WEST SUSSEX COUNTY COUNCIL CONSULTATION

TO:	Arun District Council FAO: Amber Willard
FROM:	WSCC - Highways Authority
DATE:	25 May 2022
LOCATION:	Stoneyfield Cottages, Eastergate Lane, Eastergate, PO20 3SL
SUBJECT:	BN/48/22/PL Variation of condition imposed under BN/112/21/PL relating to condition 2-plans condition.
DATE OF SITE VISIT:	N/A
RECOMMENDATION:	More Information / Modification
S106 CONTRIBUTION TOTAL:	N/A

FOR MR & MRS MITCHELL		
SITE SITE AT: STONEFIELD NURSERY, EASTERGATE LANE, EASTERGATE. PO20 3SL		
TITLE SITE PLAN SHOWING PROPOSED DWELLING		
SCALE 1:100 © A2	DATE 03/22	DRAWING NO. 01P REV C

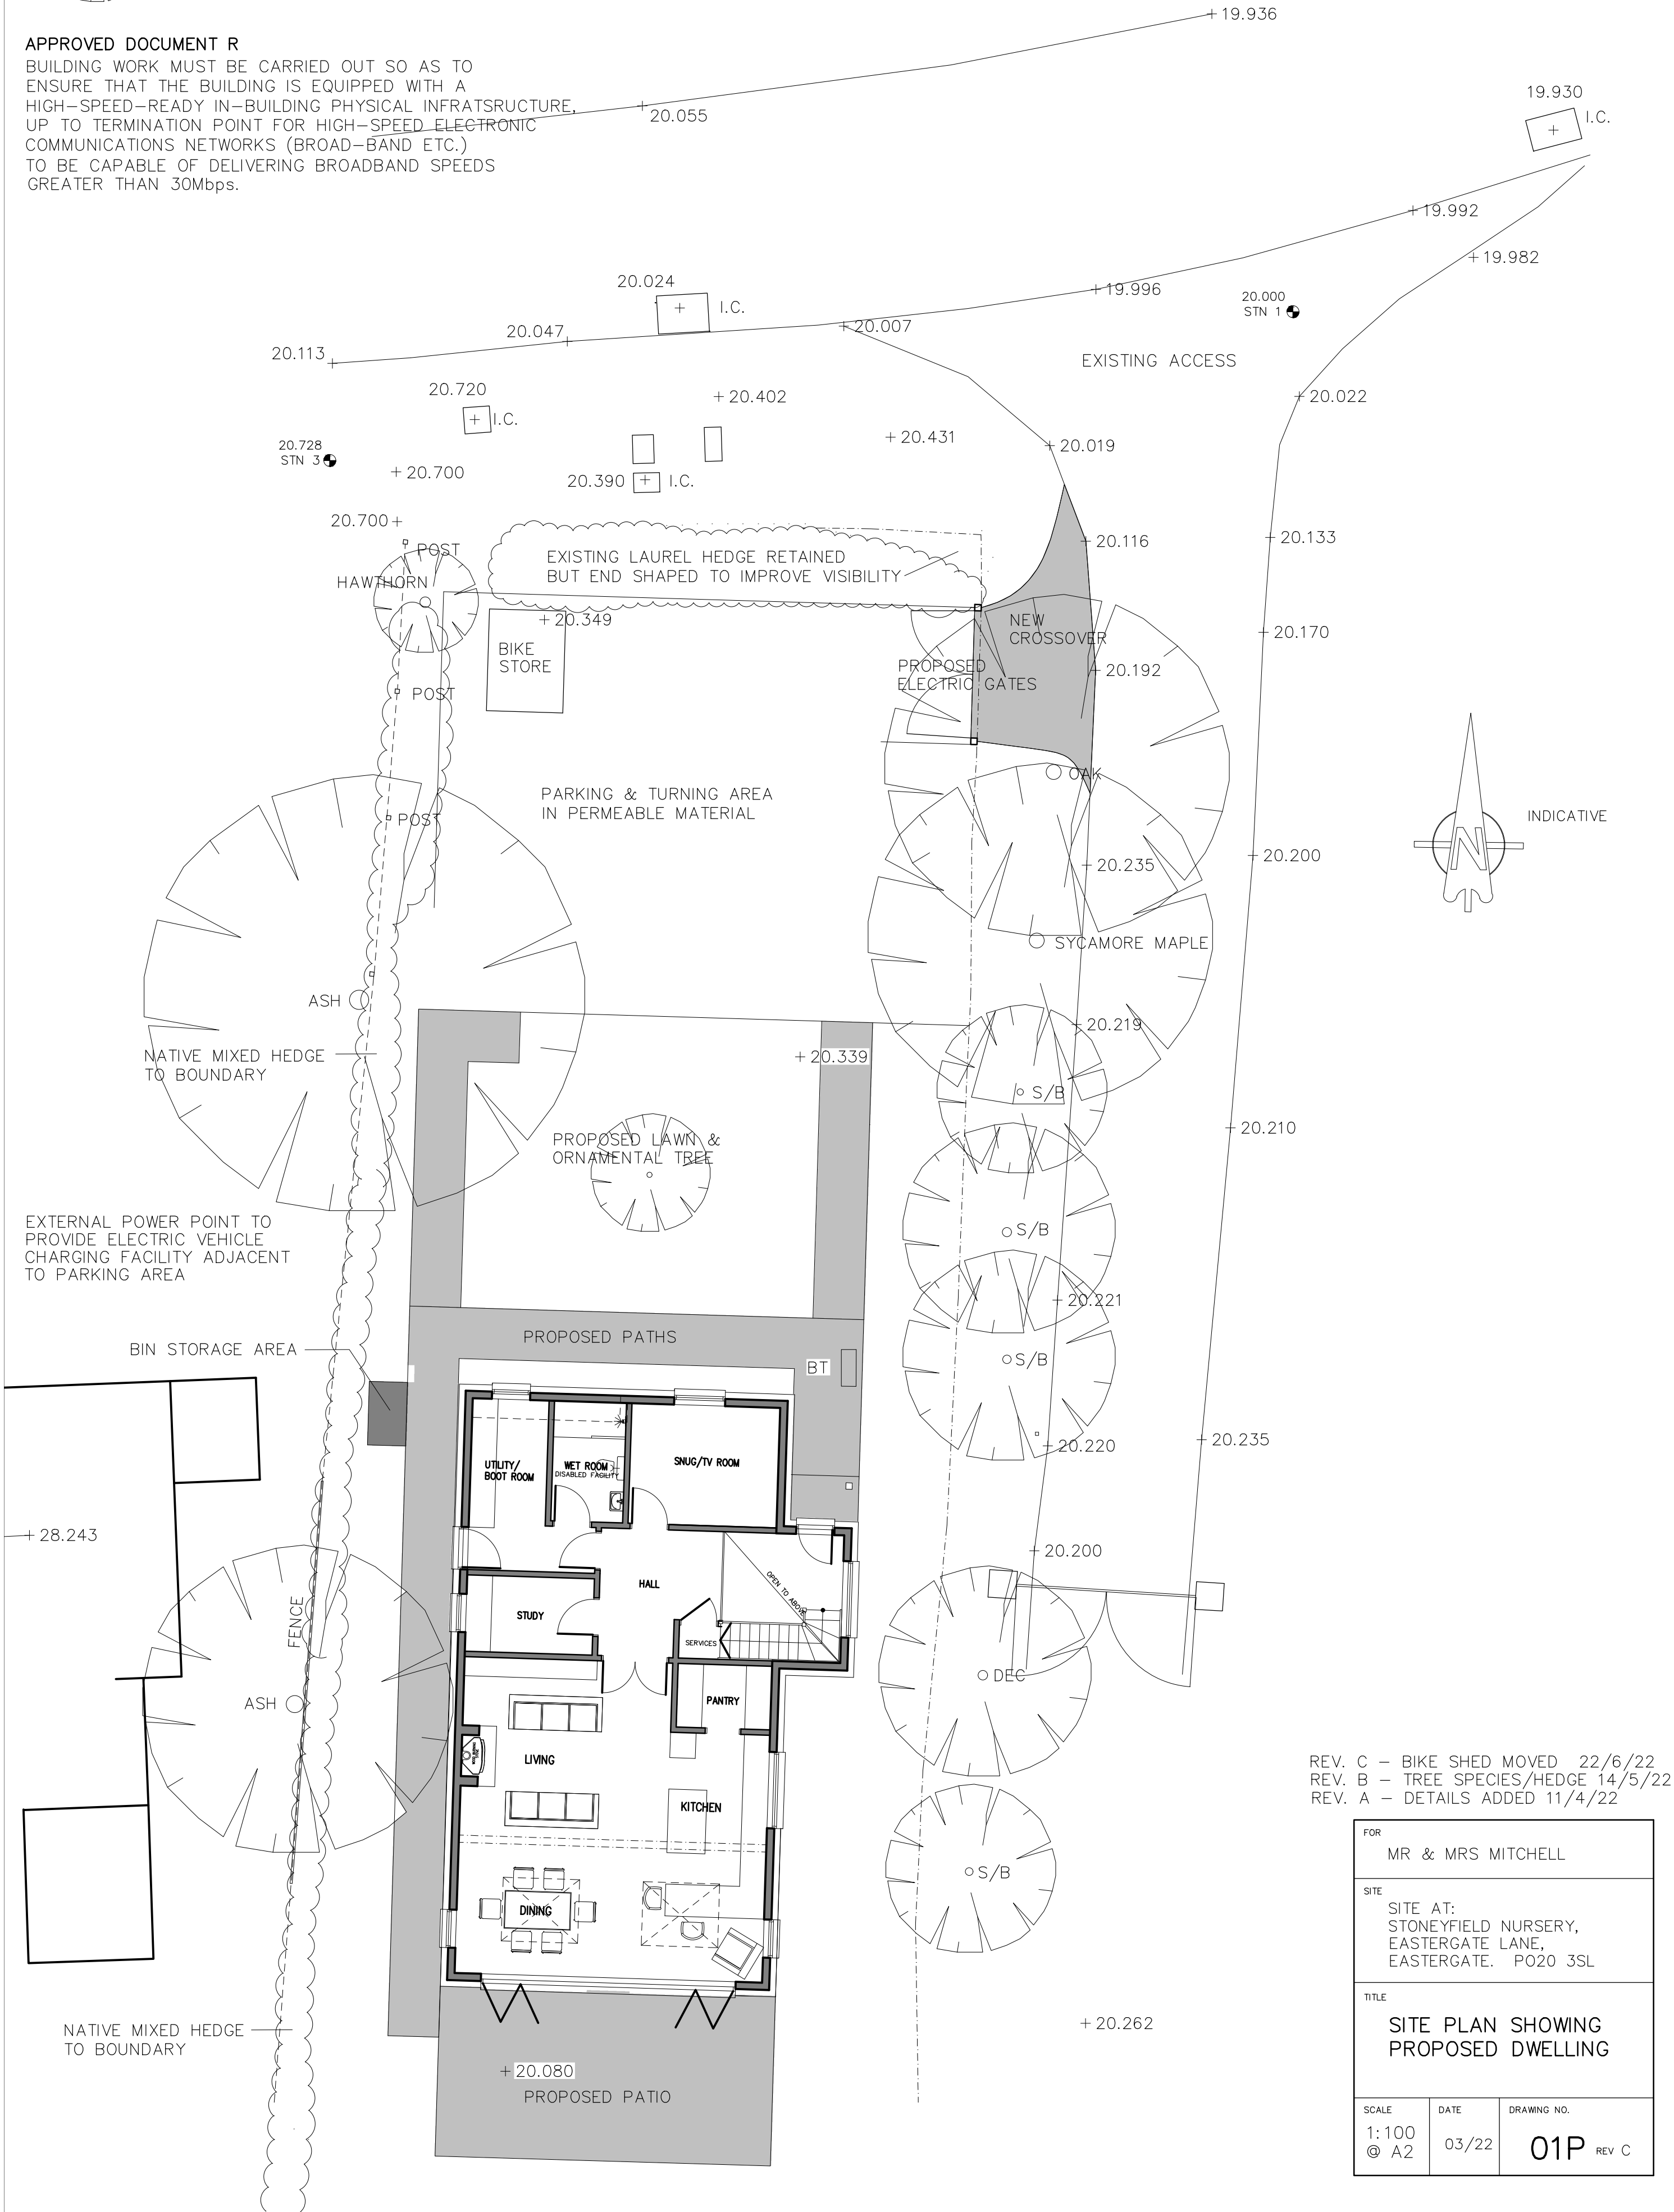
One point to raise would be the relocation of the proposed access. Generally, vehicle crossovers should be located at least 10m from a junction. The access as proposed appears to be located approximately 7m from the edge of Eastergate Lane. The proximity of the proposed access to the highway may be exacerbated by the fact the proposed access is somewhat obscured by the existing hedge line.

Whilst the LHA acknowledges that this is a privately maintained road, the LHA would request that the access be relocated at least 10m back from the edge of Eastergate Lane, as to not present a potential hazard from vehicles turning in from the maintained highway.
